CITY OF ALBUQUERQUE

PLANNING DEPARTMENT – Development Review Services

October 12, 2015

RE: **Catholic Charities**
Conceptual Drainage Plan for Site Development for Building Permit
Engineer's Stamp Date (none) (File: L12D012)

C-101

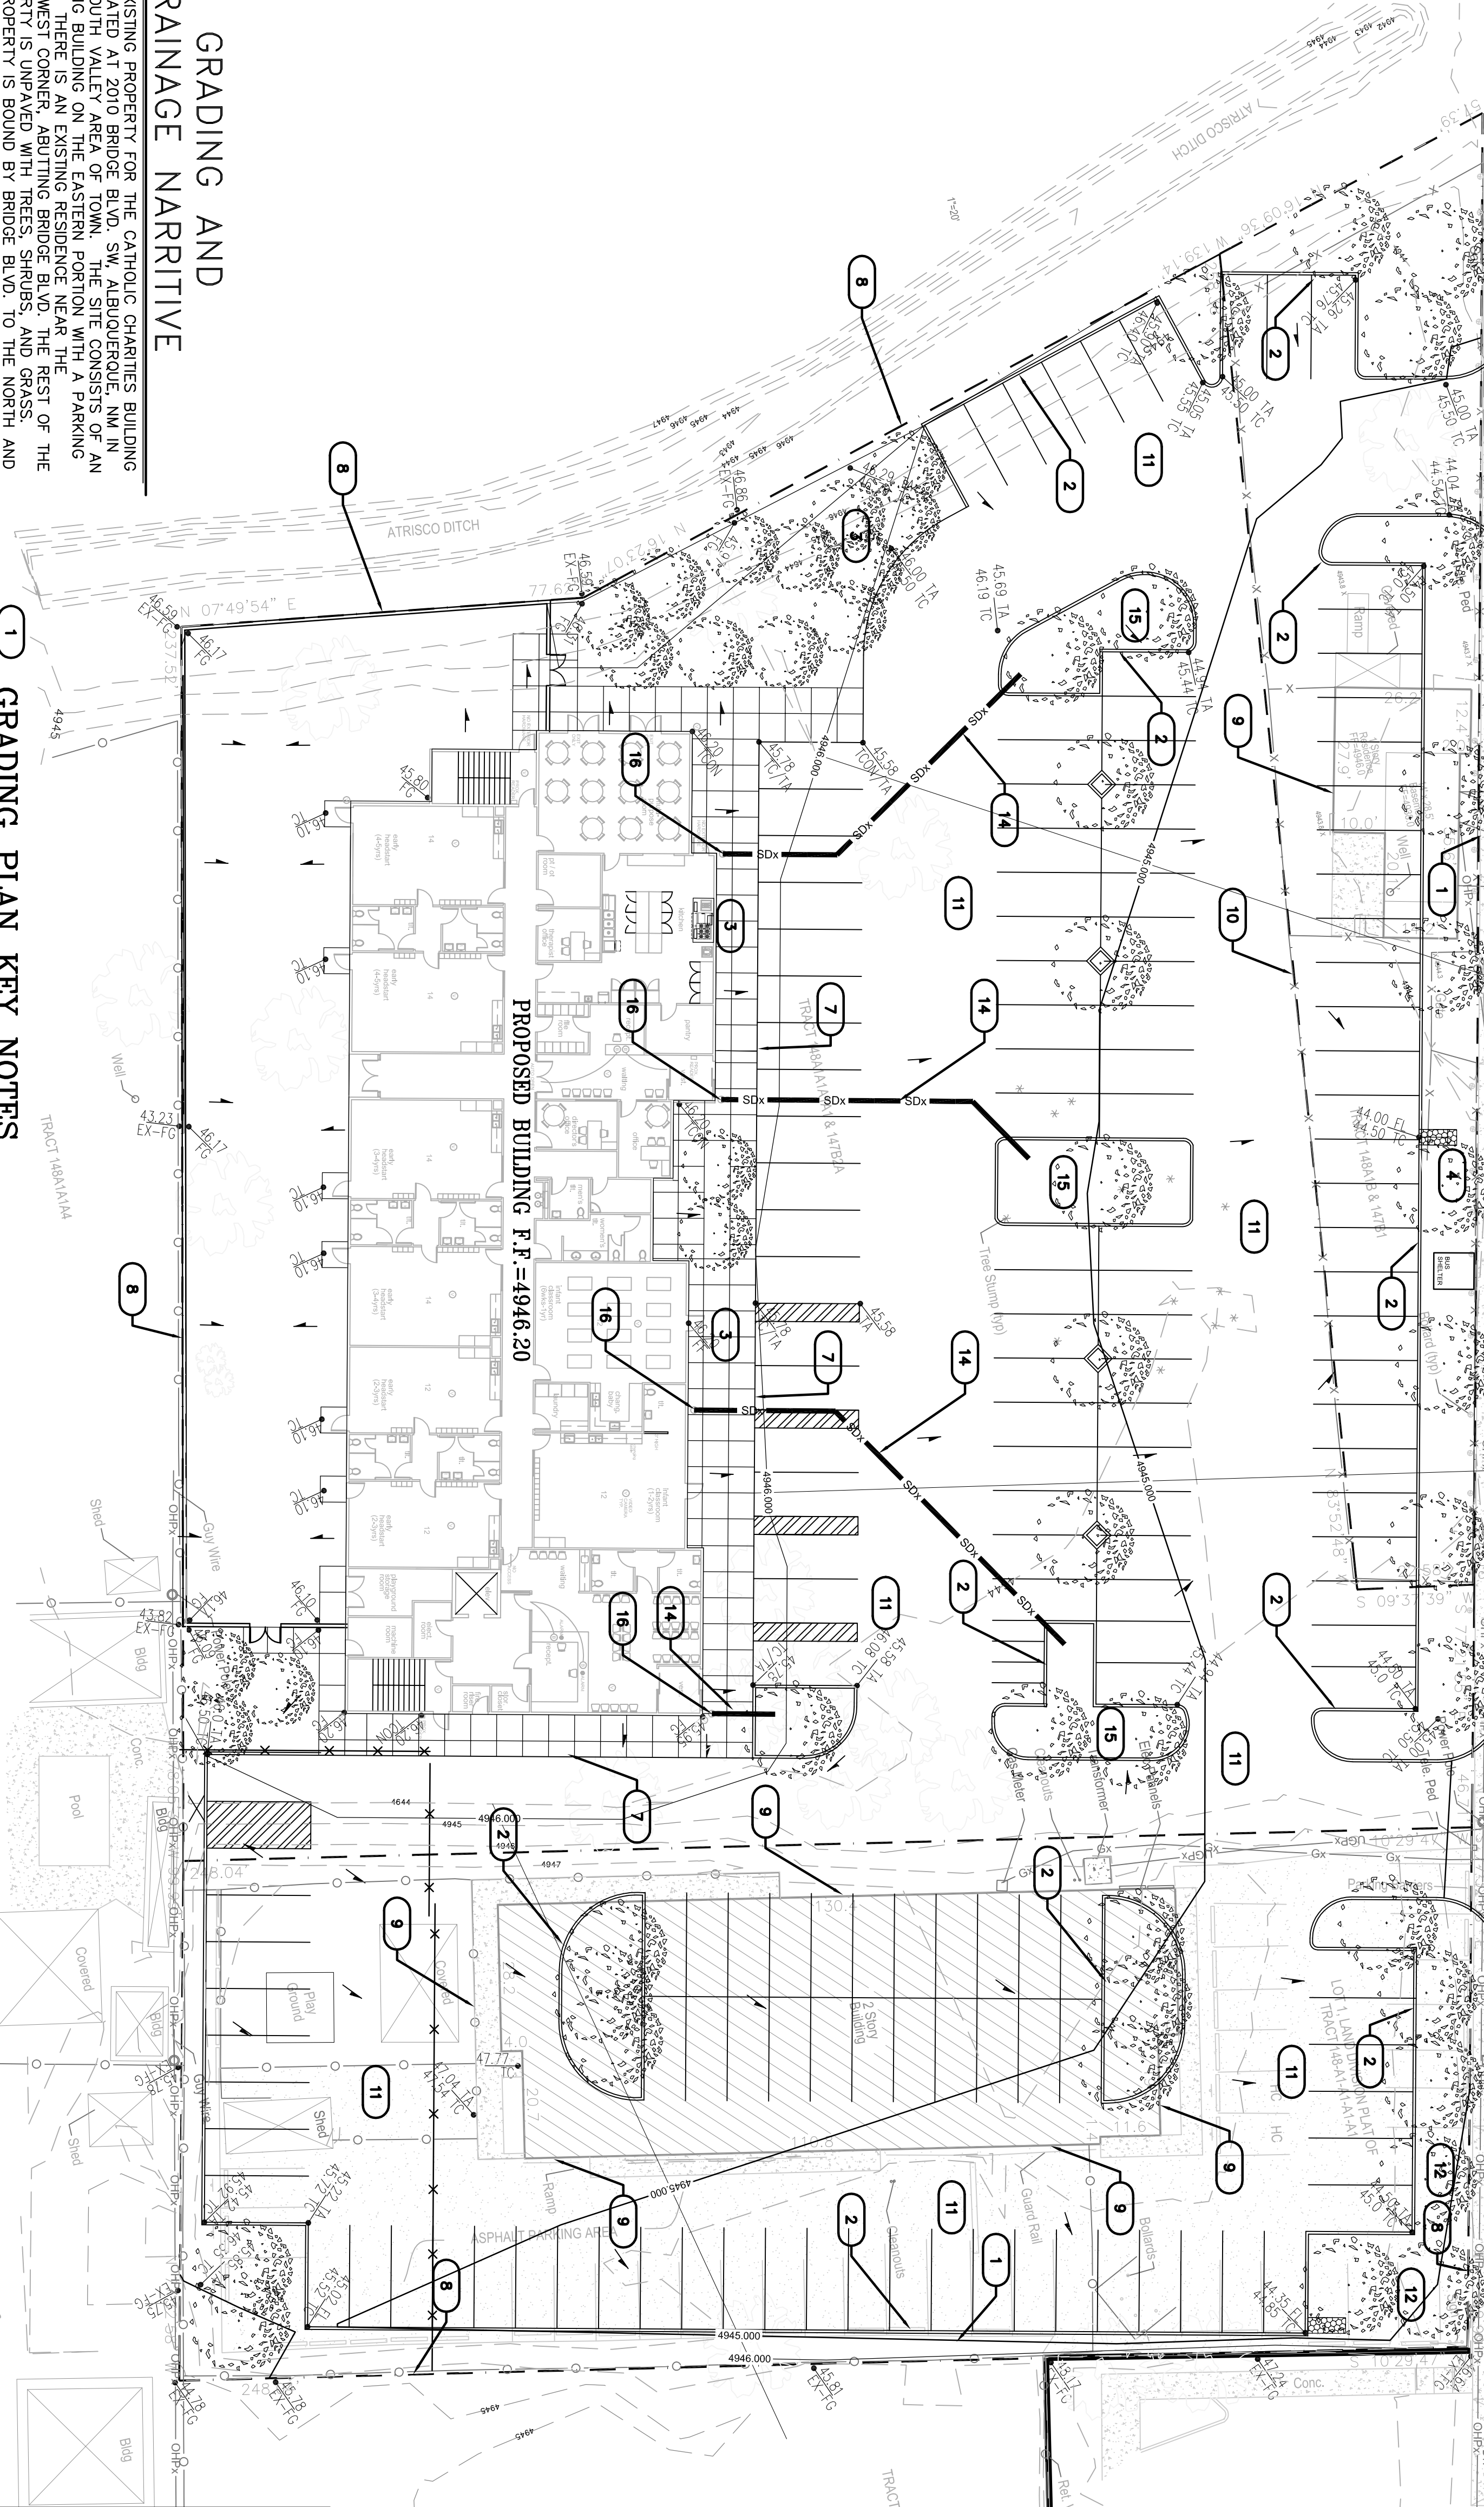
1. Runoff calculations, pond volume calculations, and "First Flush" calculations need to be provided.
2. The Vicinity Map and FEMA FIRMette should be on the Conceptual plan. Include on the Building Permit G&D plan.

3. Show Bench Mark
4. Show and call out all curb cuts, particularly on the 2 main ponds south of Bridge.
5. Call out Rip-Rap
6. Provide more TA , TS, and TC elevations to better understand the drainage around the building.

7. Show TC elevations of high and low side of curbs around water harvesting ponds.
8. Show Roof Flow arrows. Does any roof flow discharge to the south?
9. Roof Storm Drain pipe at NE corner of building extends to water harvesting pond closer to the building. Call out this area as a Water Harvesting Pond.

10. All Parking Islands and landscape islands which are used for Water Harvesting need to have contours and elevations so that they are constructed as such. State that any landscaping rock should be below these elevations.

11. How will area on South side of building drain?
12. In the narrative, use "first flush" rather than " 90th percentile..."
13. Keyed note 13 is not shown on the plan. Show SW culverts. Show or state that plates are to extend out 2 ft, and bolts to be tack welded to the plate.

14. If work in the ROW is to constructed per SO-19 Permit, then be sure SO-19 Notes are on the G&D plan. Include "SO-19" in the Title for the construction notes as well as a signature block for the Street Maintenance Inspector.

16. Curb returns need to be detailed on the Grading plan since it is not going to be reviewed in the DRC/Work Order Process.
